Your Ref: OWPC6399
Our Ref: Y/40/15/PL 01-05-2015
Please ask for:
Andrew Wood

Installation of 4 no. 1.2 x 1.2 UPVC white double glazed windows. Change of use from B1 (Business) & B8 (Storage & Distribution) to sheltered employment.

23/24 Orchard Business Park North End Road Yapton

PROPOSED INSTALLATION OF
4 NO 1.200 X 1.200 WHITE UPVC D/GLAZED
SINGLE OPENING WINDOWS SOUTH
SIDE

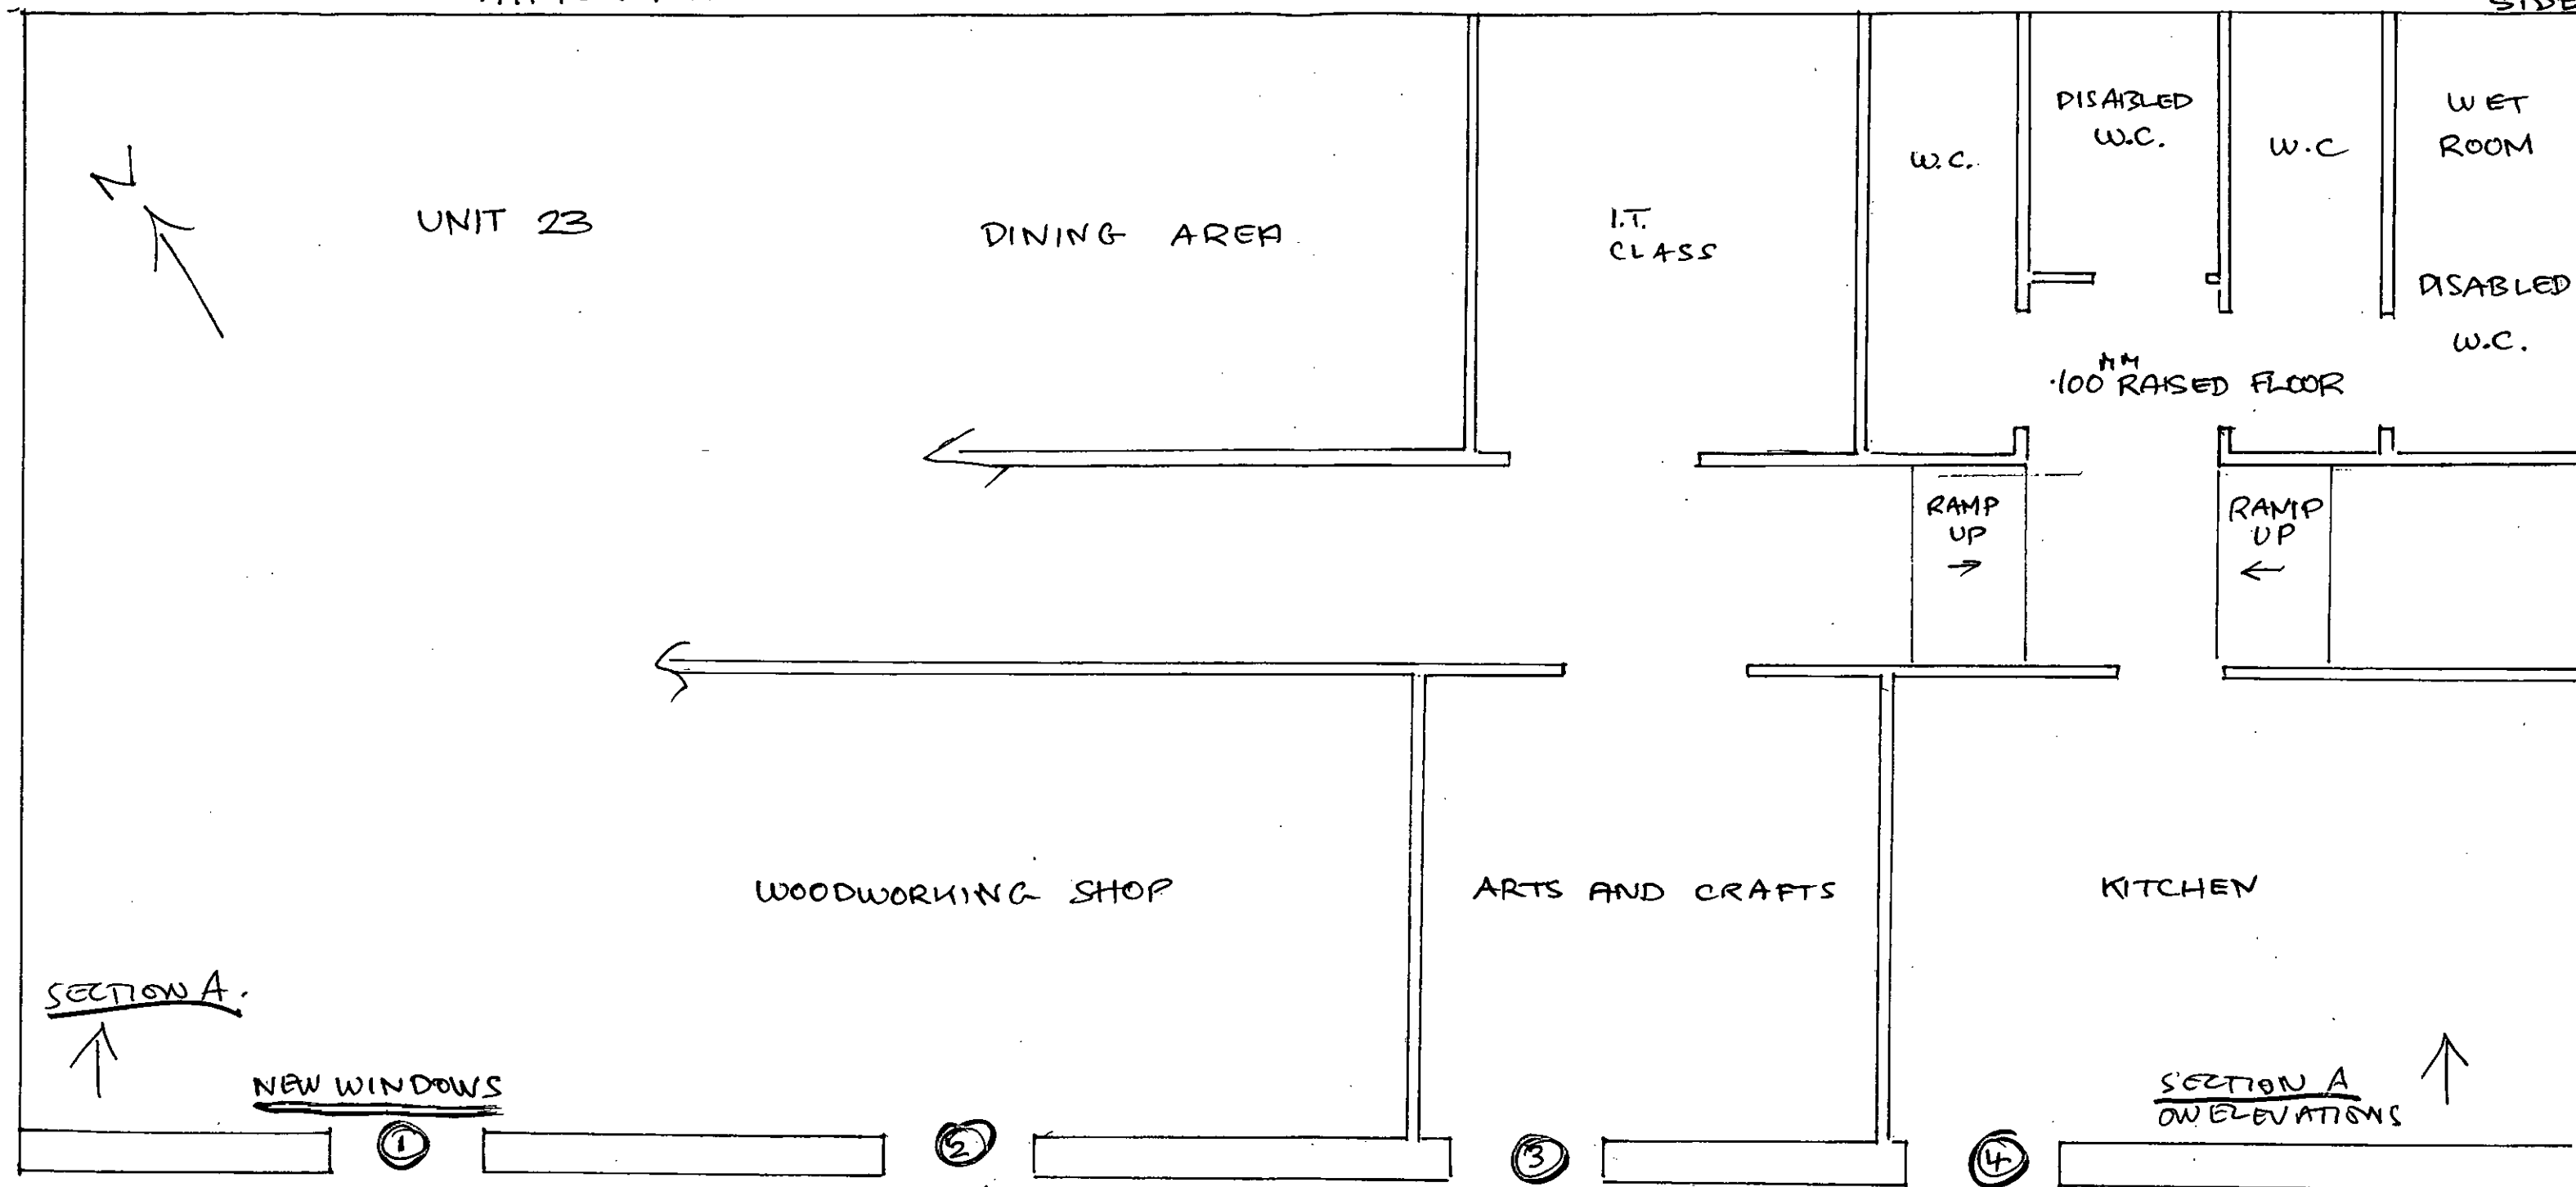
- 1. Security. Since the windows have been installed, we have already had to chase from our premises, two persons trying to gain access via these windows.*

- 2. The windows impinge on our privacy. They currently give a clear and full view of our property.*
- 3. If this planning application is approved, this will set a precedent and the three adjoining units will undoubtedly require windows, thus creating the potential for 16 windows directly looking over our garden.*

- 4. All the units currently have skylights. It was suggested that these could be converted to Velux windows to provide the additional light required, the additional airflow requested and would have no effect on our privacy. This suggestion was rejected because the windows had already been installed, without the the required permissions.*

- 5. Arun District Council's suggestion that we 'put up a fence' would negate the point of windows as the light and ventilation would be blocked as the windows are directly on our boundary.*
